| Consultation Response from: KC Environmental Health (Pollution & Noise Control) | | |
| 2024/90187 - Former Moldgreen Top Club, 15, Church Street, Moldgreen, Huddersfield, HD5 9DL | | |
| Change of use of ground floor from licensed premises to offices | | |
| Responding Date: 21 March 2024 | Responding Officer: Mohammed Nasim | Responding Ref: WK202406680 |

Proposed Block Plan (1:200 @ A1).

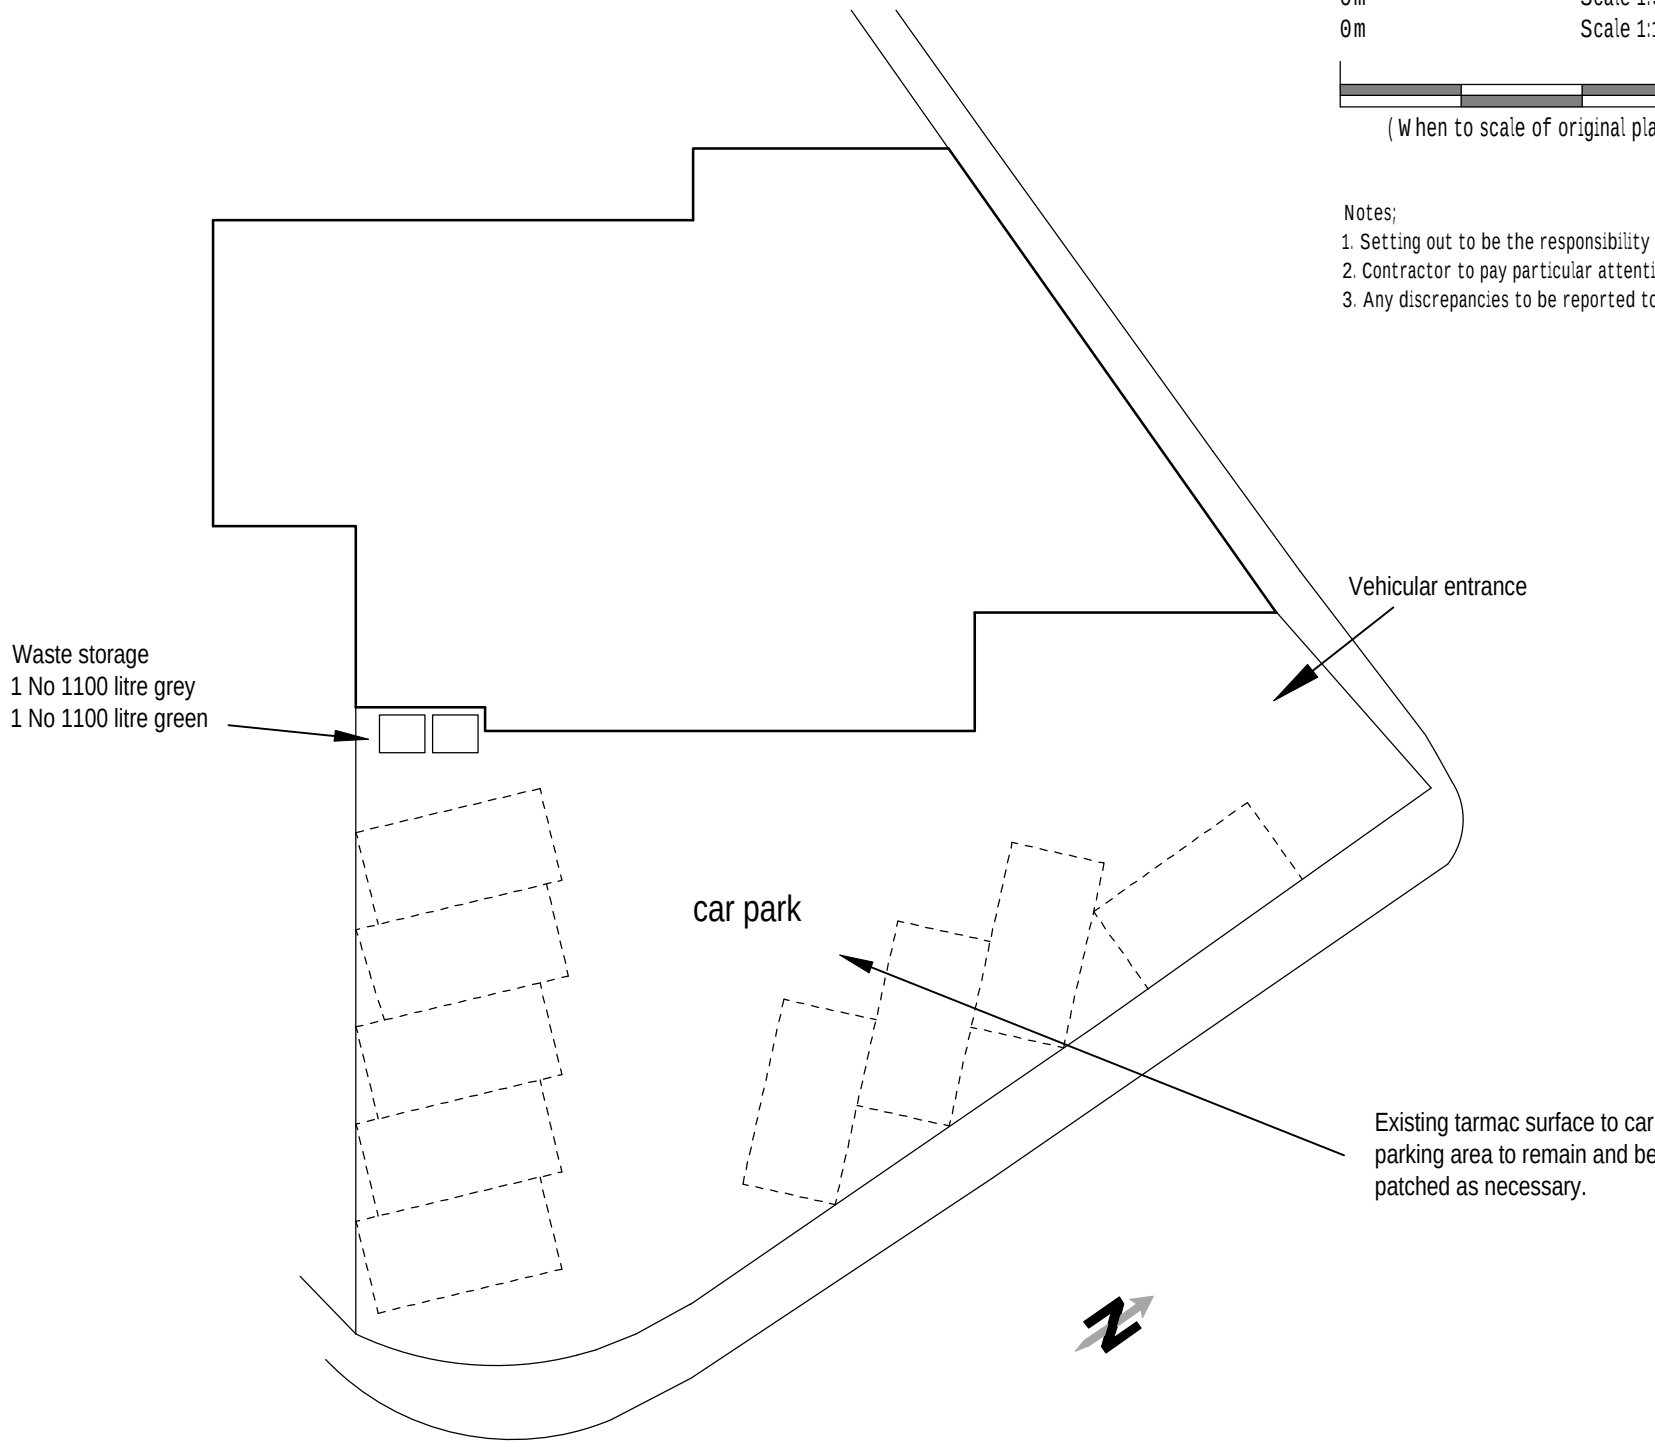
Before first occupation, a scheme outlining the specific facilities for charging electric vehicles and other ultra-low emission vehicles for 10% of the total parking spaces at the premises must be submitted to and approved in writing by the Local Planning Authority. This scheme must meet the minimum requirements in the current West Yorkshire Low Emission Strategy (WYLES) document. The approved facilities for charging electric vehicles must be installed before occupation and retained for use thereafter.

Proposed Ground Floor Layout Plan (1:50 @ A1).

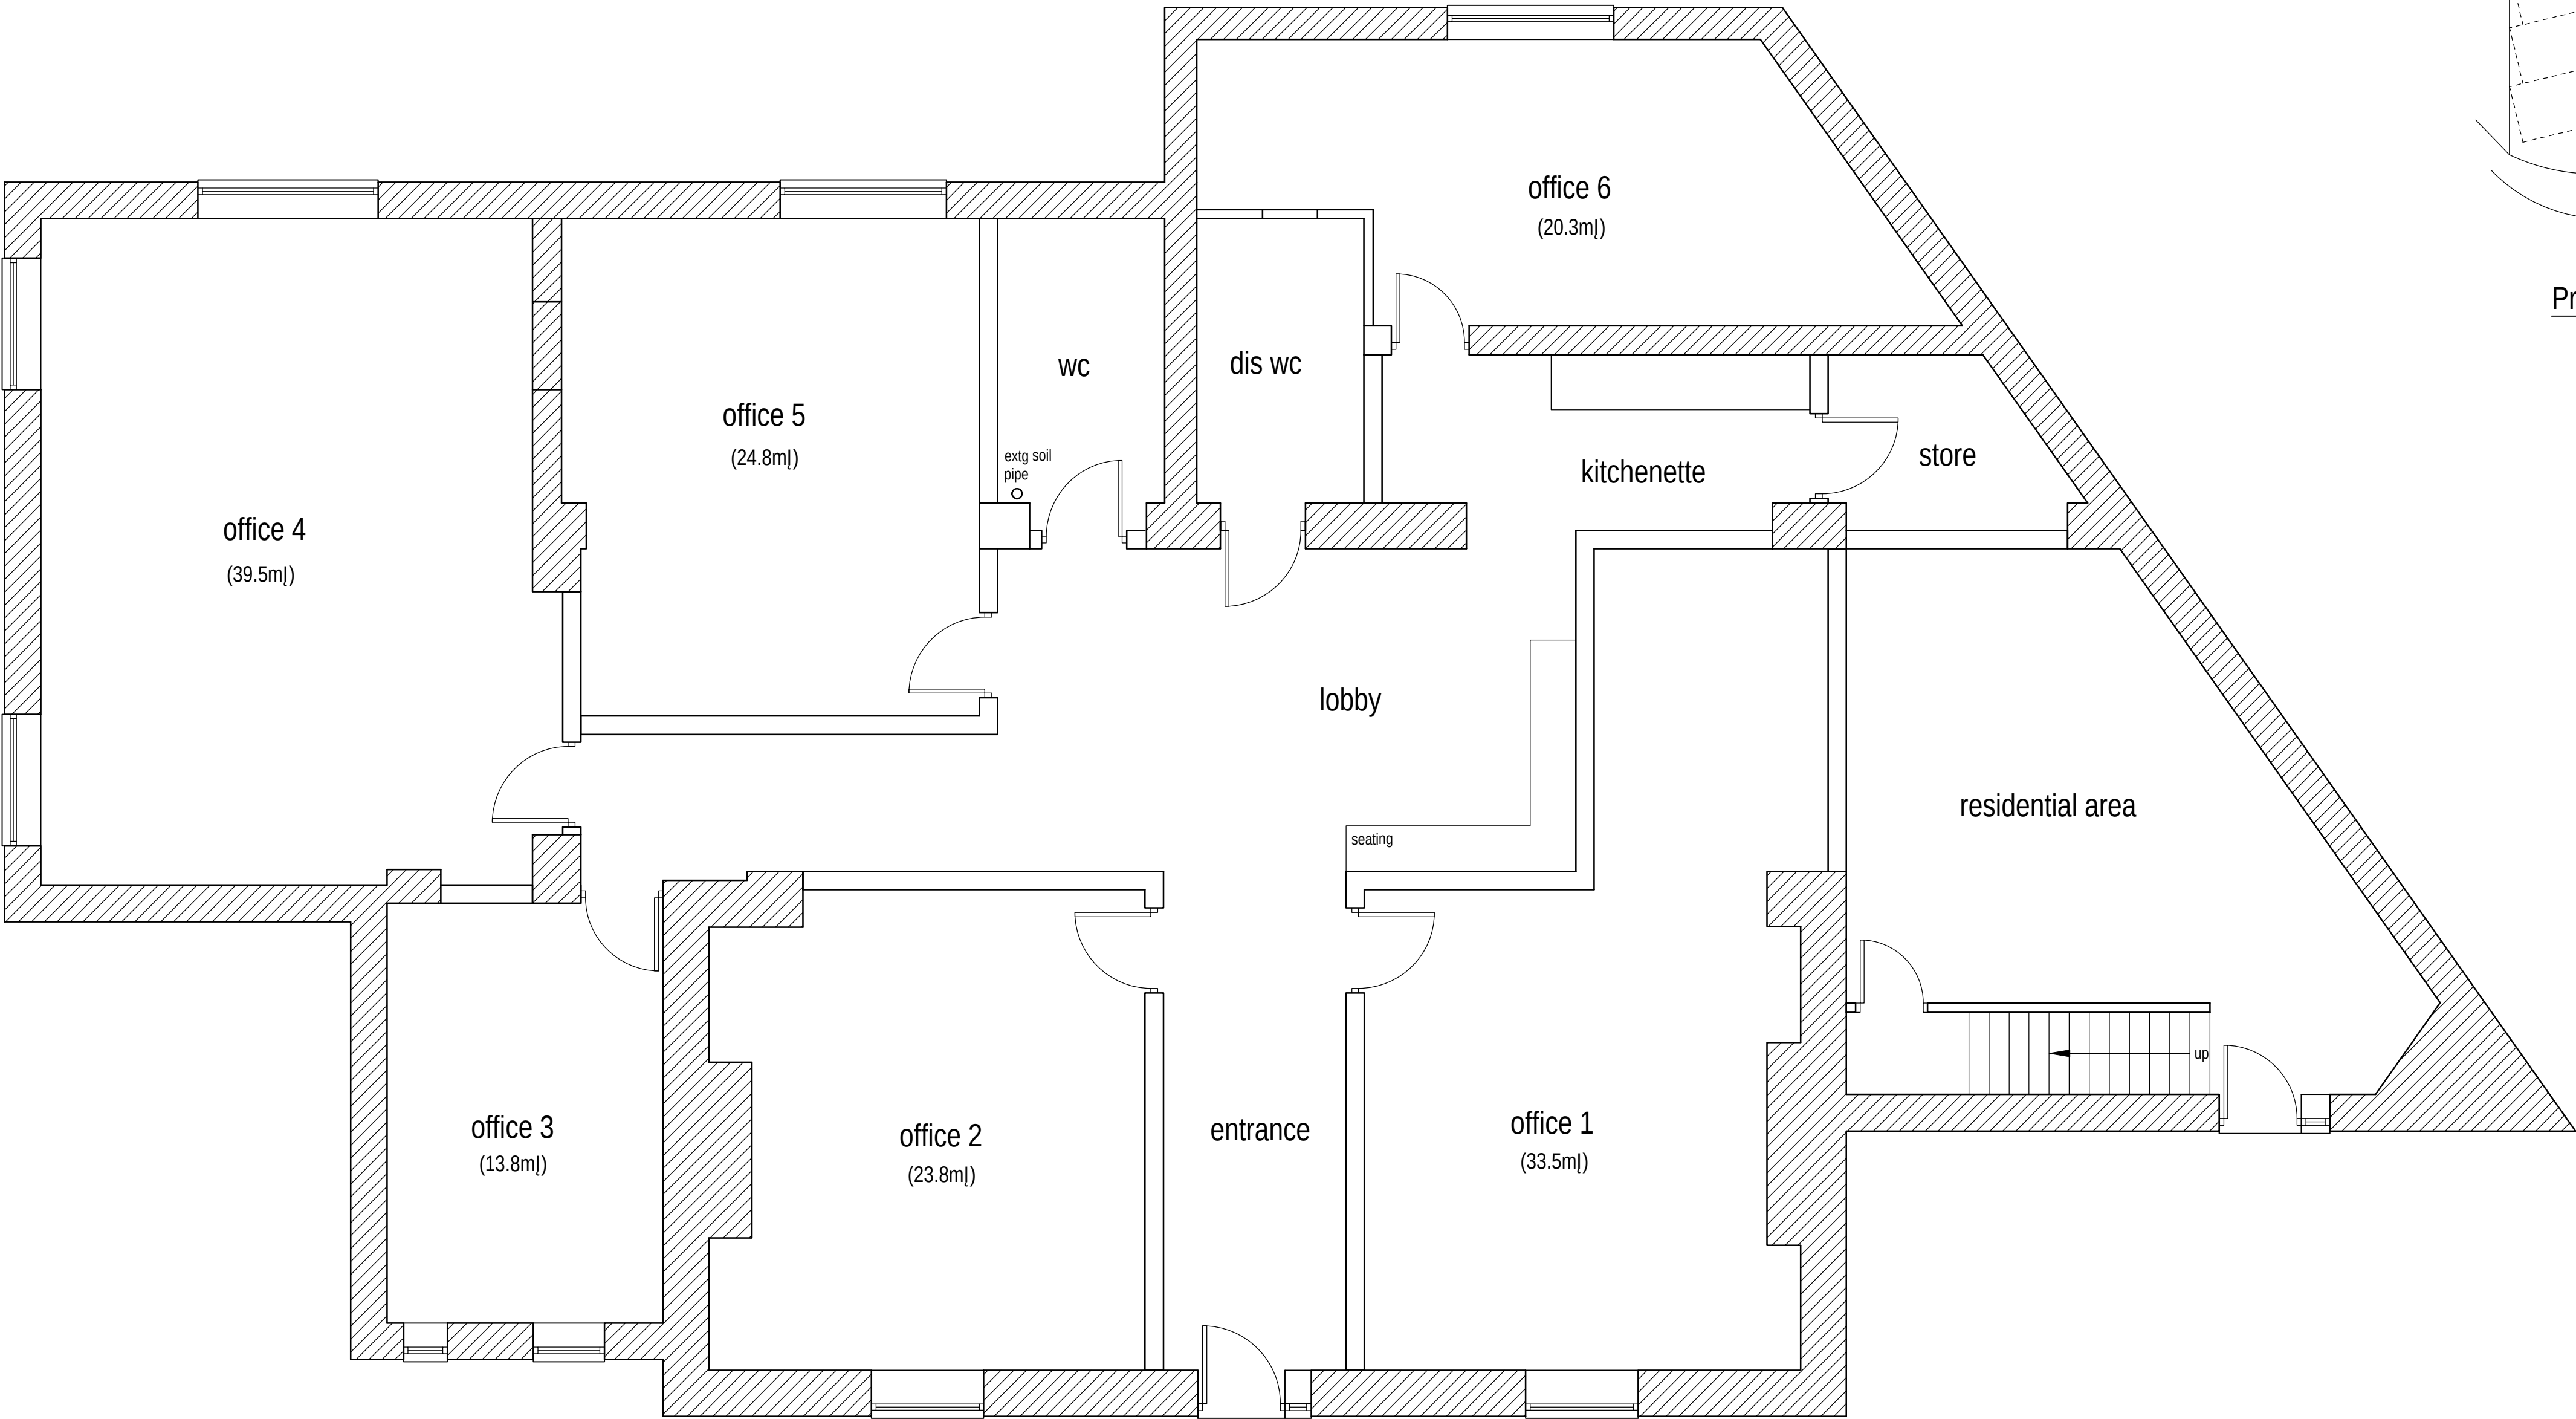
| <p><u>Comments</u></p> <p><u>Noise</u> The proposal is to refurbish the existing living accommodation to the first floor and convert the former licensed area at the ground floor into offices. We would expect a higher level of sound insulation where residential and commercial premises share a party wall/floor/ceiling and a condition is recommended in order to protect the amenity of future occupiers.</p> <p><u>Electric Vehicle Charging Points (EVCPs)</u> In an application of this nature, it is expected that facilities for charging electric vehicles and other ultra-low emission vehicles are provided in accordance with the National Planning Policy Framework and <i>Air Quality & Emissions Technical Planning Guidance</i> from the West Yorkshire Low Emissions Strategy Group. A condition requiring charging points is therefore necessary.</p> <p><u>Construction</u> The hours of construction will need to be controlled in order to protect the amenity of the neighbouring properties.</p> <p><u>Recommended Conditions</u></p> <p>NC6 For use where proposed commercial and residential share a party structure (floor / ceiling or wall etc) – Condition Before the development is brought into use written evidence to demonstrate that the airborne sound insulation performance of the party floors/walls/ceiling of the development is of a minimum of 55dB $D_{nT,w} + C_{tr}$ shall be submitted to and approved in writing by the Local Planning Authority. If it cannot be demonstrated that the aforementioned airborne sound insulation performance has been achieved, a scheme incorporating further measures to achieve the sound insulation performance shall be submitted to and approved in writing by the Local Planning Authority. All works comprised within those further measures shall be completed and further written evidence to demonstrate that the aforementioned sound insulation performance level has been achieved shall be submitted to and approved in writing by the Local Planning Authority before the development is first brought into use.</p> <p>Reason: To protect the amenity of occupiers of the proposed development from noise or disturbance from nearby noise generating premises to accord with the aims of Policies LP24 and LP52 of the Kirklees Local Plan and Chapters 12 and 15 of the National Planning Policy Framework.</p> <p>NF4 Competent Person - Footnote All Noise Assessments should be carried out by a competent person. The applicant may wish to contact the Association of Noise Consultants http://www.association-of-noise-</p> | | |
